Application number: 2025/65/90441/E	
What is the application for?:	Listed Building Consent for conversion of existing listed church to 2 dwellings,
Address of the site or building:	Church of the Holy Innocents, Vicarage Road, Dewsbury, WF12 9PD
Postcode:	BD19 5LX

PROPOSED SITE PLAN SCALE 1:100

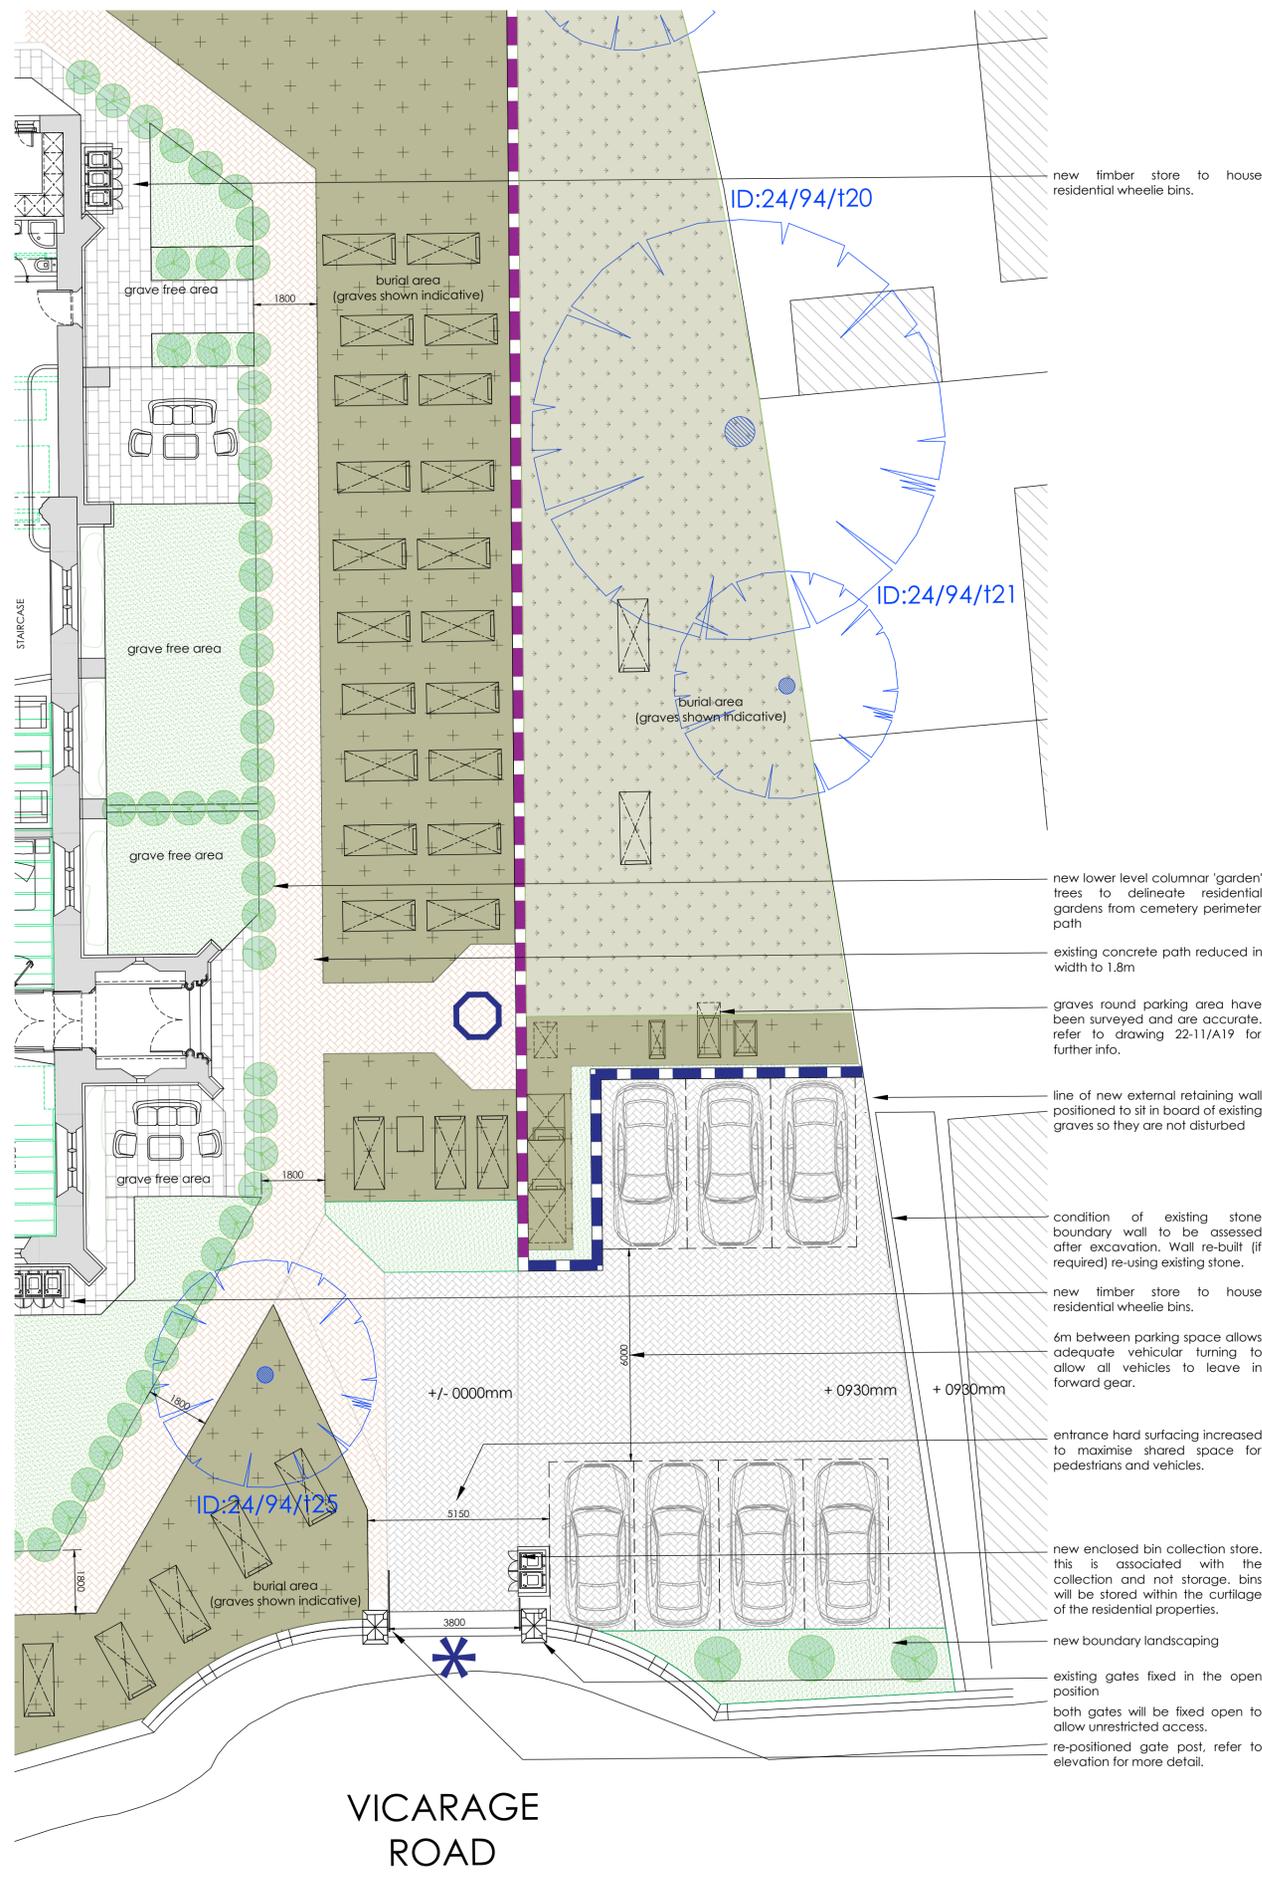
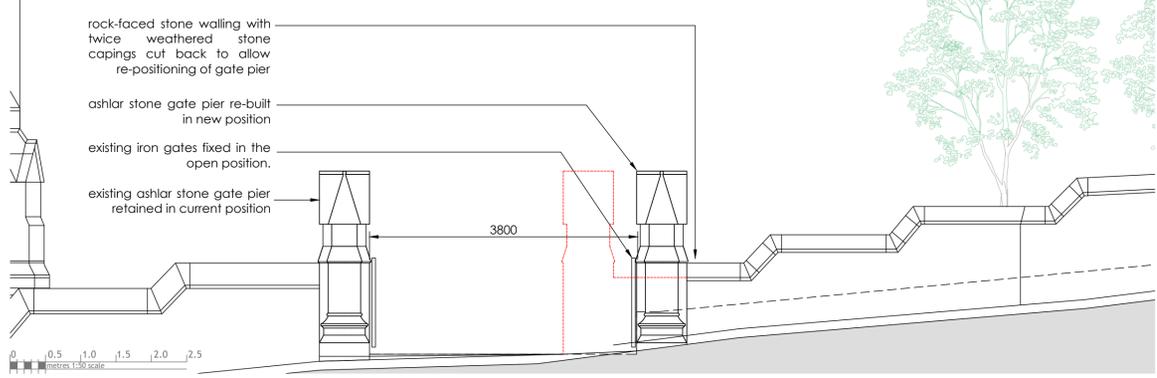
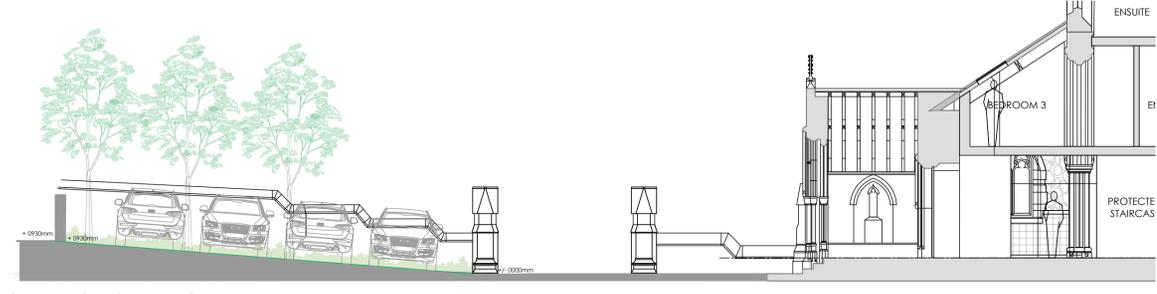
Type of comment: An objection	
Do you wish your comments to be published on the website anonymously?	<input type="checkbox"/> Yes
Both of my parents and various other relatives are buried within the graveyard. It is both disgraceful and disrespectful that a parking area is even considered where graves exist and where I and other families involved currently tend the graves of our loved ones.
